Existing House lot.

Applicant: W. A. One (Jim Wolf)

Address: 1670 Forest Ave.

CHECK-LIST AGAINST ZONING

**SITE AND UTILITY PLAN**  
1"=10'

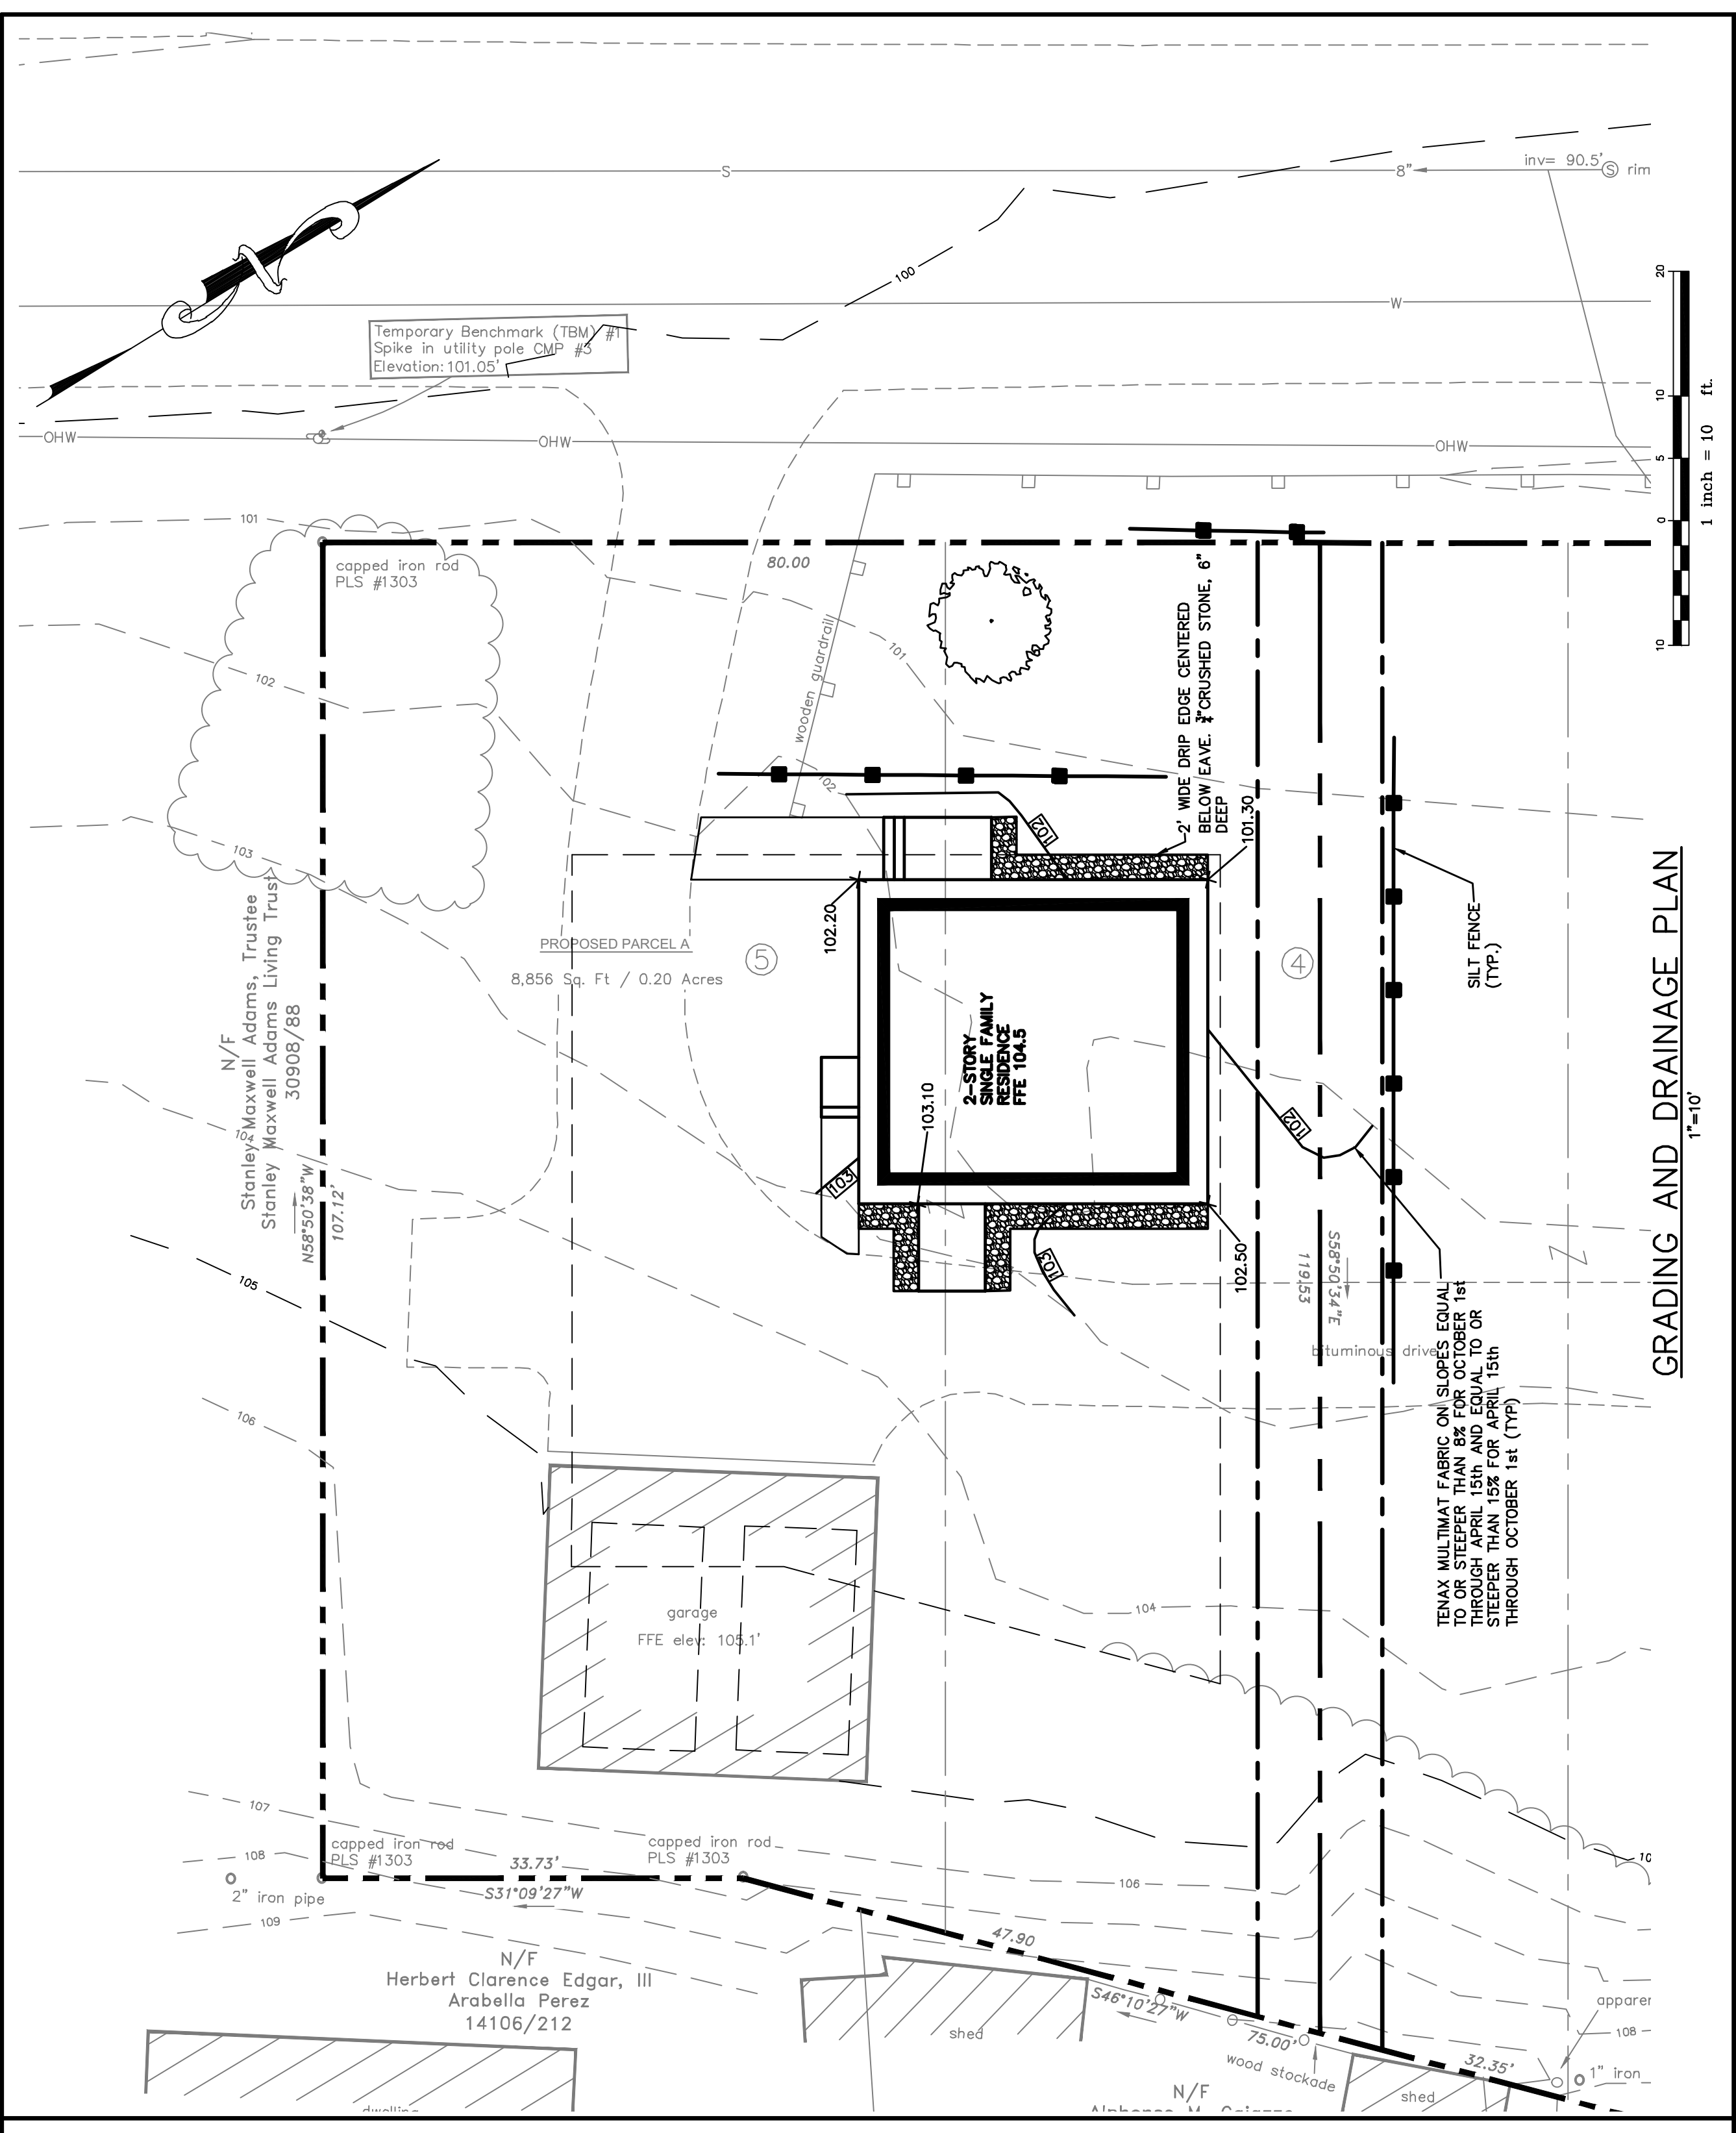
* Off-street Parking - need to show two parking spaces - two shown beyond 20' side yard on side street on driveway plan
